PLANNING CONSULTATION RESPONSE

Application No	2026/0292
Proposal	External alterations and installation of doorway to provide level access, as well as internal alterations including installation of platform lift and extension of ATM room.
Address	26 Market Hill, Barnsley, S70 2QE
Date of Consultation Reply	10.06.2026
Consultee	Charlie Atkinson Design & Conservation Assistant

Project: **Level Access Program**
 Title: **Barnsley Proposed Plan & Elevation**
 Client: **NatWest Group**
 Purpose: **For planning**
 Drawing Number: **7119-JMA-14-00-DR-A-000012**

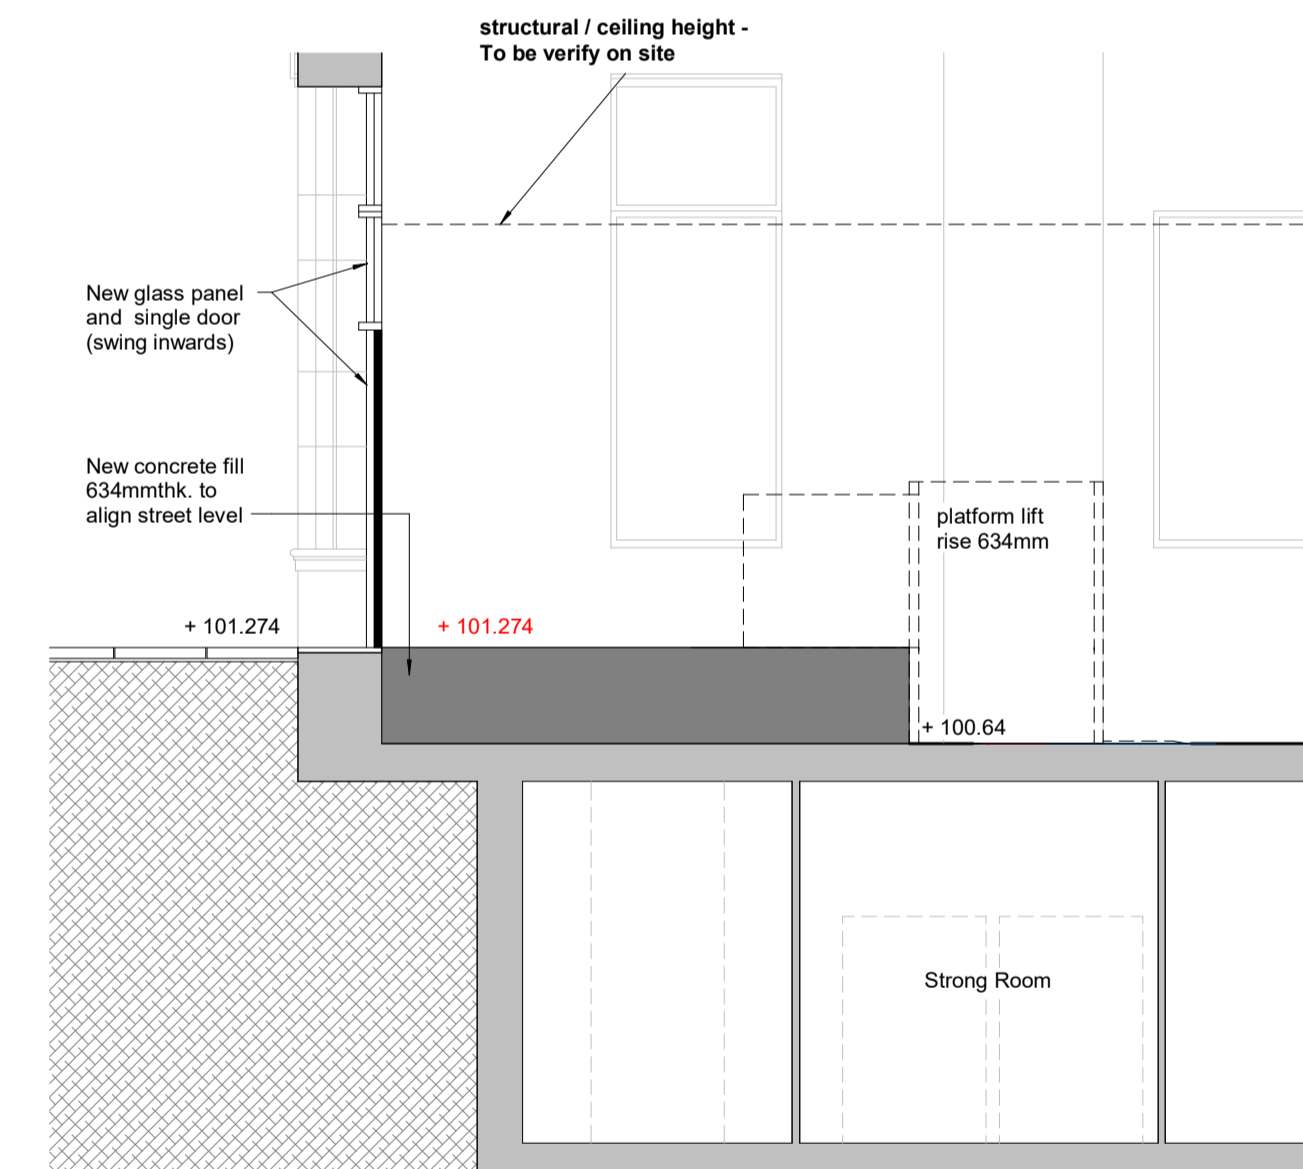
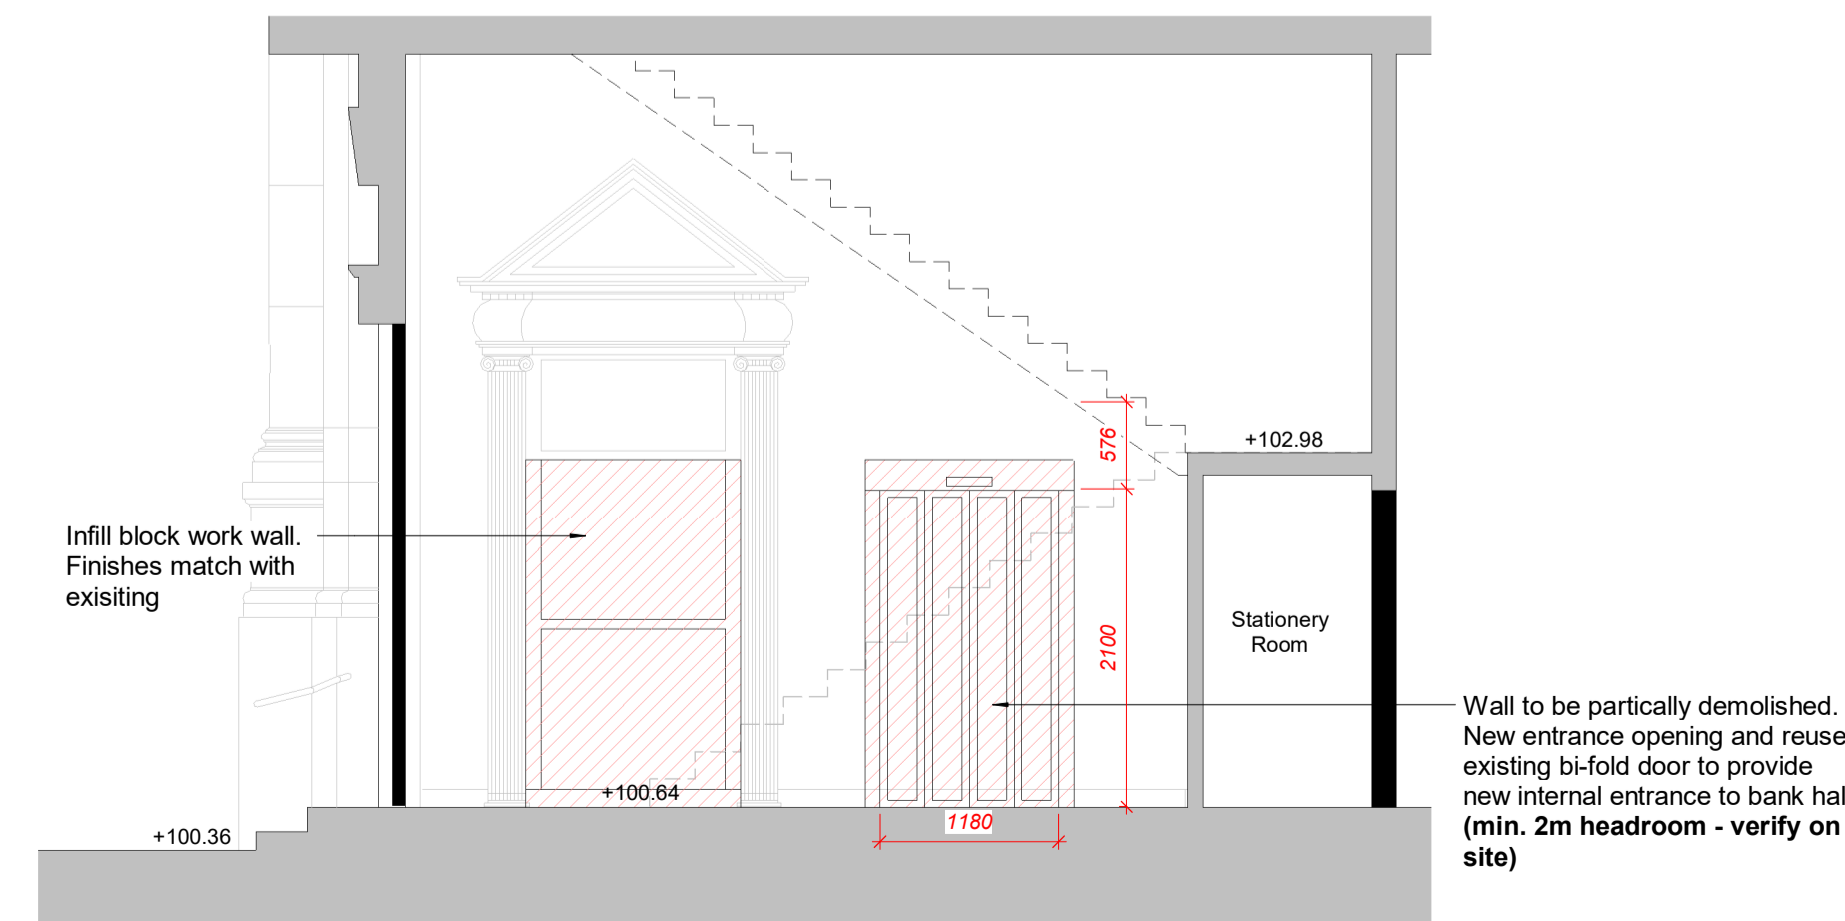
Whilst the interior of the building holds some interest, the proposed internal alterations are limited to modern partitions and therefore do not raise significant conservation concerns. The primary consideration from a conservation perspective is the alteration to the external fabric including the conversion of an existing ground floor window (first from the left) into a doorway, resulting in the loss of a section of low-level stonework. This intervention is relatively minor in scale, and the justification in terms of improving accessibility is considered to outweigh the very little impact, supporting the continued use and viability of the building. However, further detail is required in respect of the design and detailing of the proposed doorway, ensuring that it sits comfortably within the existing opening in terms of proportions, materials and colour – conditions have therefore been included below.

- Notwithstanding the submitted details, prior to the installation of the doorway hereby approved, full detailed drawings of the new door and frame (at a scale of 1:10 or 1:20), including cross-sections and reveals, and samples or a specification of the materials and external finish shall be submitted to and approved in writing by the Local Planning Authority. The development shall be carried out in accordance with the approved details and retained thereafter.
- The external materials shall match those used in the existing building and specified by the approved documents listed above. The stone shall match the existing in terms of type, colour, and face dressing (for the stone) and method of coursing and pointing. The quoining and arch jamb shall also match the existing.
